WEST SUSSEX COUNTY COUNCIL CONSULTATION

TO:	Arun District Council FAO: Anita Gardner
FROM:	WSCC - Highways Authority
DATE:	30 May 2019
LOCATION:	5 Arundel Road, Littlehampton, BN17 7BY
SUBJECT:	LU/164/19/PL Change of use from trophy/medal shop (A1 shops to Hot food takeaway (A5 Hot Food Takeaway), shopfront amendments, installation of extract outlets on north & west elevations, installation of condenser unit on west elevation & installation of roof-mounted extract flue & fresh air intake pipe.
DATE OF SITE VISIT:	N/A
RECOMMENDATION:	Advice
S106 CONTRIBUTION TOTAL:	£N/A

Studio Lack Architecture Studio Lack Ltd : 17 Beech Avenue : Chichester 01243 782 686 : nicholas.lack@live.com : PO19 3DR	5 Arundel Road, Littlehampton	Block/Site Plan 28/03/19 1/500 @ A4	Dwg 1915-03C
--	---	---	-------------------------

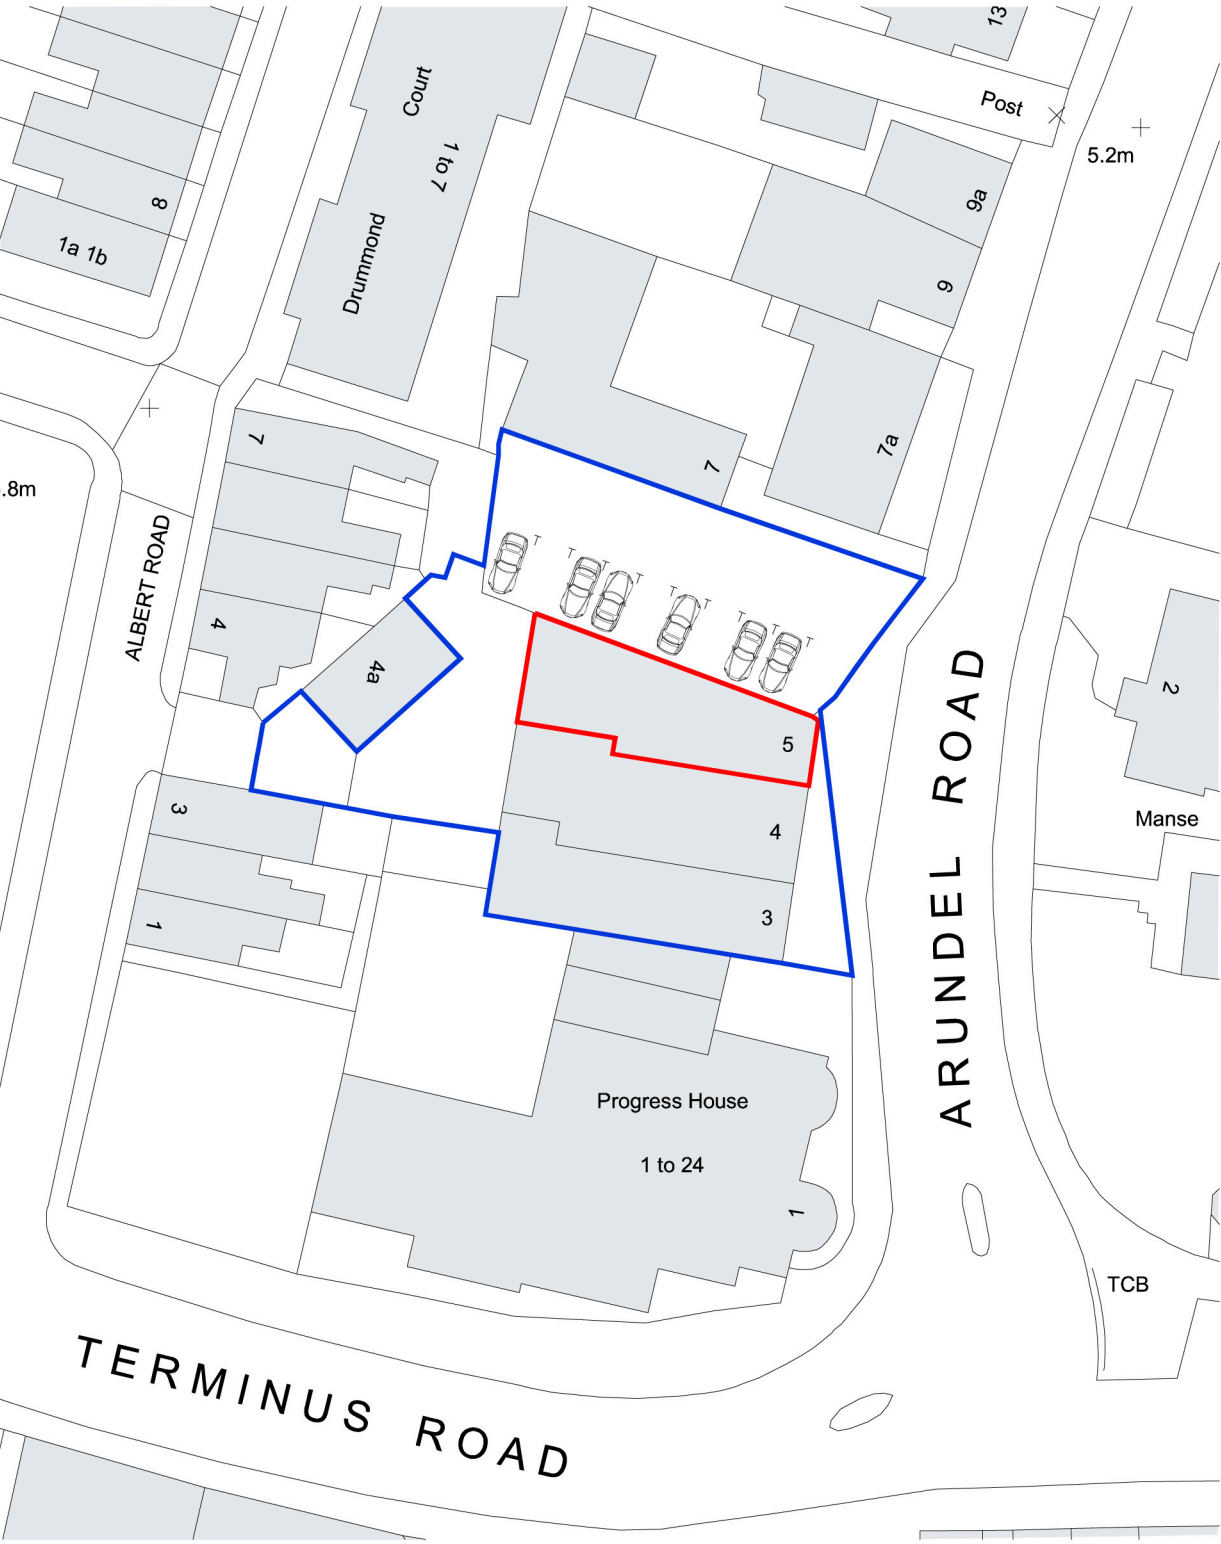
The existing car park is accessed via Arundel Road. An inspection of collision data provided to WSCC by Sussex Police from a period of the last 5 years reveals no recorded injury accidents within the vicinity of the site resulting from road layout. Therefore there is no evidence to suggest the access is operating unsafely or that the change of use would exacerbate an existing concern.

The car park to the north of the site containing 10 parking spaces is reserved for customers of the proposed takeaway and the 2 neighbouring shops south of the site. The level of traffic generated by the conversion from retail to café would be of a similar nature, albeit at different times of the day. Therefore the parking provision is deemed sufficient.
